## **Suffolk County Council (20041323)**

Comments on any other submissions  
received at Deadline 4

## **Bramford to Twinstead (EN020002)**

Deadline 5

ELEVATION - B  
 SCALE 1:150

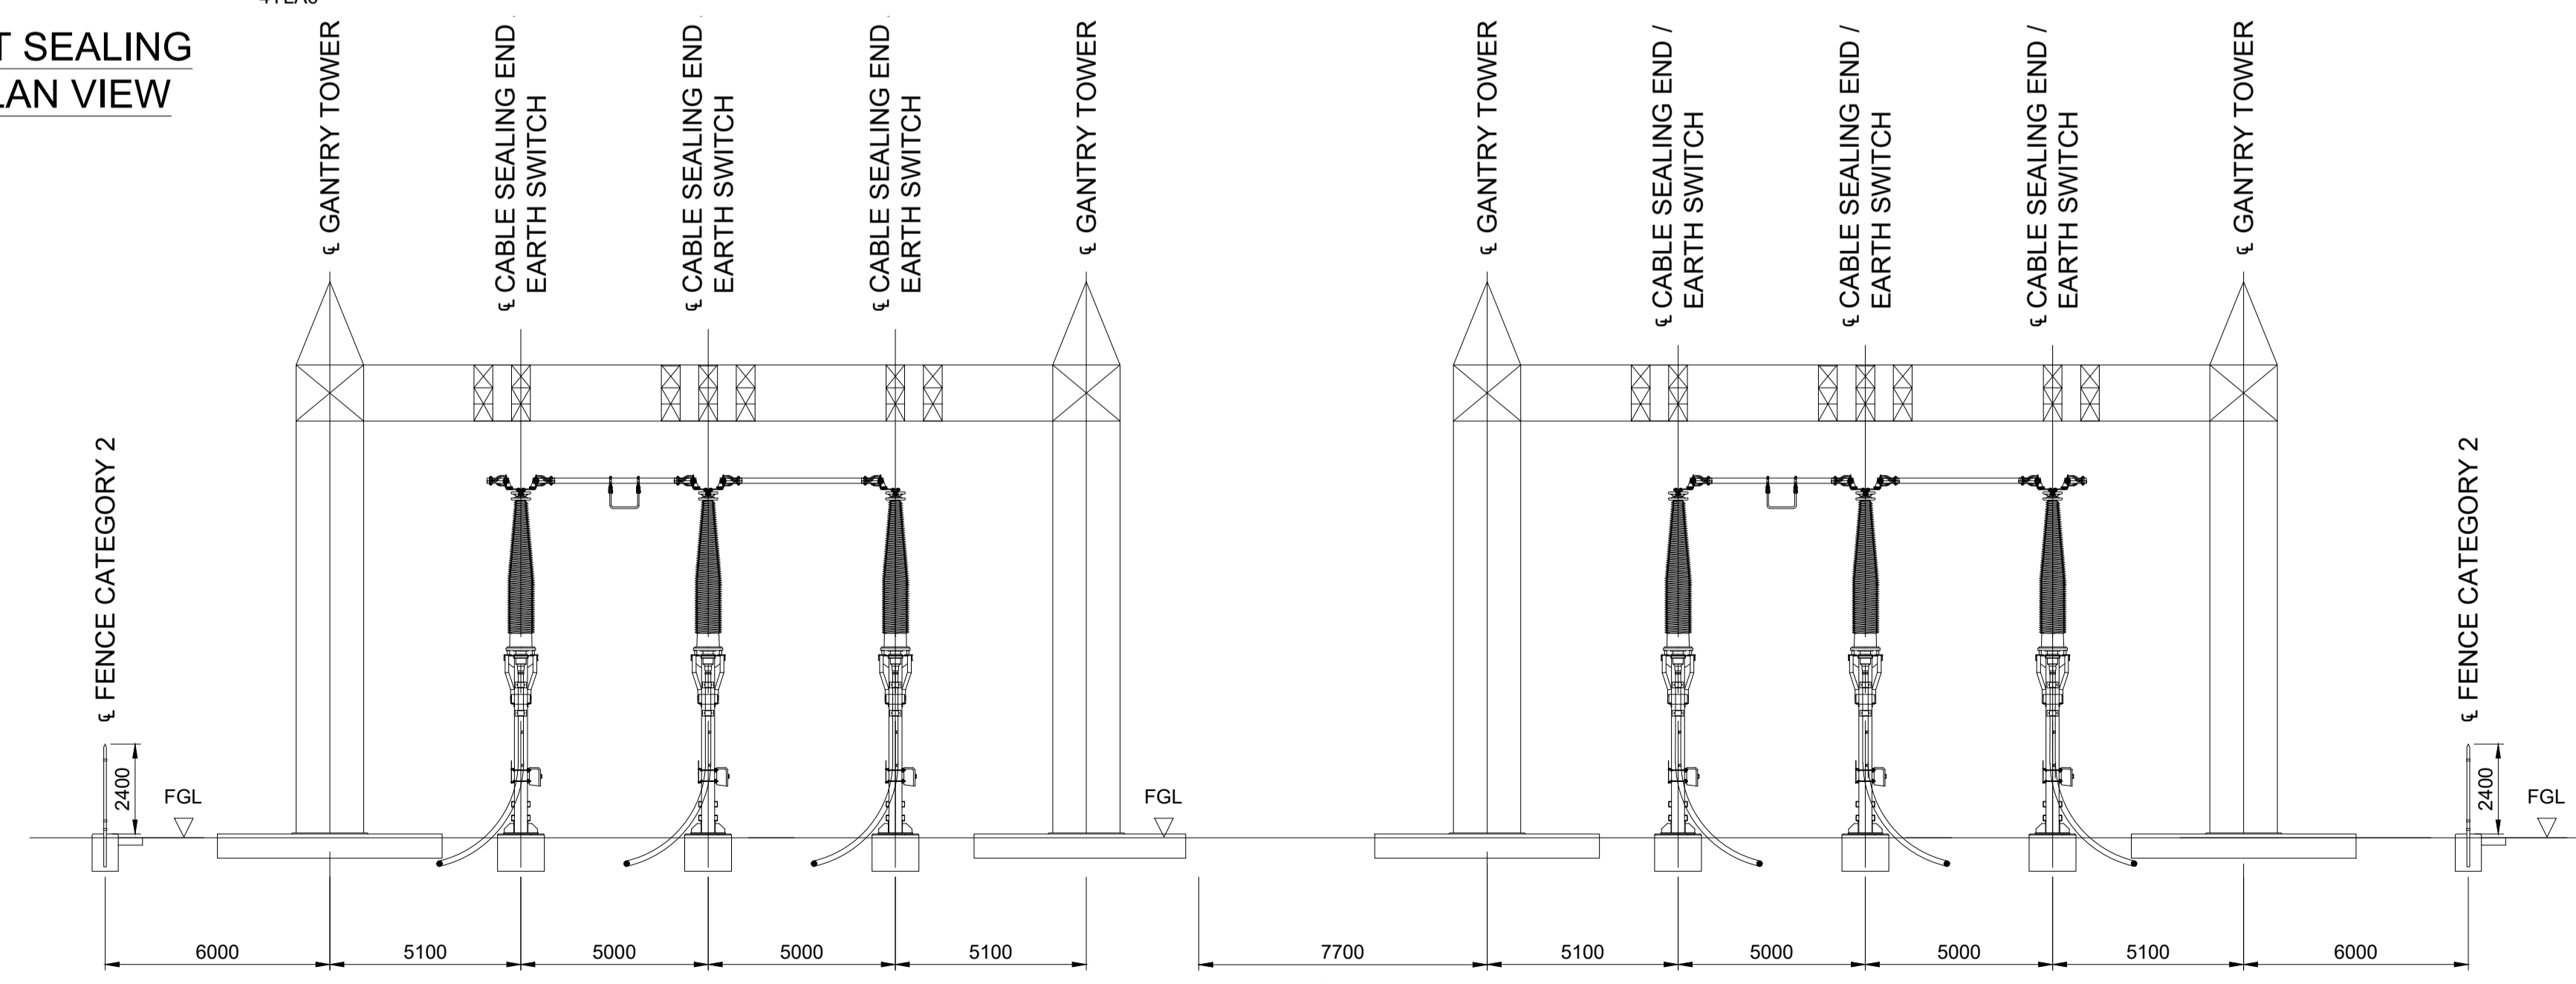
<b>Table 8: SCC Table of Comments on 8.6.3: Applicant’s Response to the November Hearings Action Points (CAH1, ISH2, ISH3, ISH4) [REP4-042]</b>			
<b>Ref</b>	<b>Topic</b>	<b>Reference Number and Comment</b>	<b>SCC’s Response</b>
8a	AP13		<p>From the Applicant’s response provided it is not clear where the permanent access route would cross Footpath W-171/001/0. SCC (Landscape) is concerned that a substantial part of the intervening vegetation that would potentially help to screen the view from across the Stour valley will be removed, not for the permanent access route, but for the works in general. This includes veteran tree T378, which according to the Applicant cannot be circumvented or drilled underneath.</p> <p>While SCC (Landscape) welcomes the commitment to ensure a landscape architect is involved in the detailed design of the permanent access route to advise on suitable finishes for the permanent access route at Stour Valley East CSE compound as part of reducing the landscape and visual effects of this feature, SCC expects that a suitably qualified landscape architect will be involved in the detailed landscape design throughout the entire project area.</p> <p>The embedded planting measures around the CSE compounds are not detailed enough to provide comfort that appropriate visual screening will be achieved.</p> <p>At the Stour Valley West CSE compound the proposed area for potential embedded planting seems insufficient.</p>
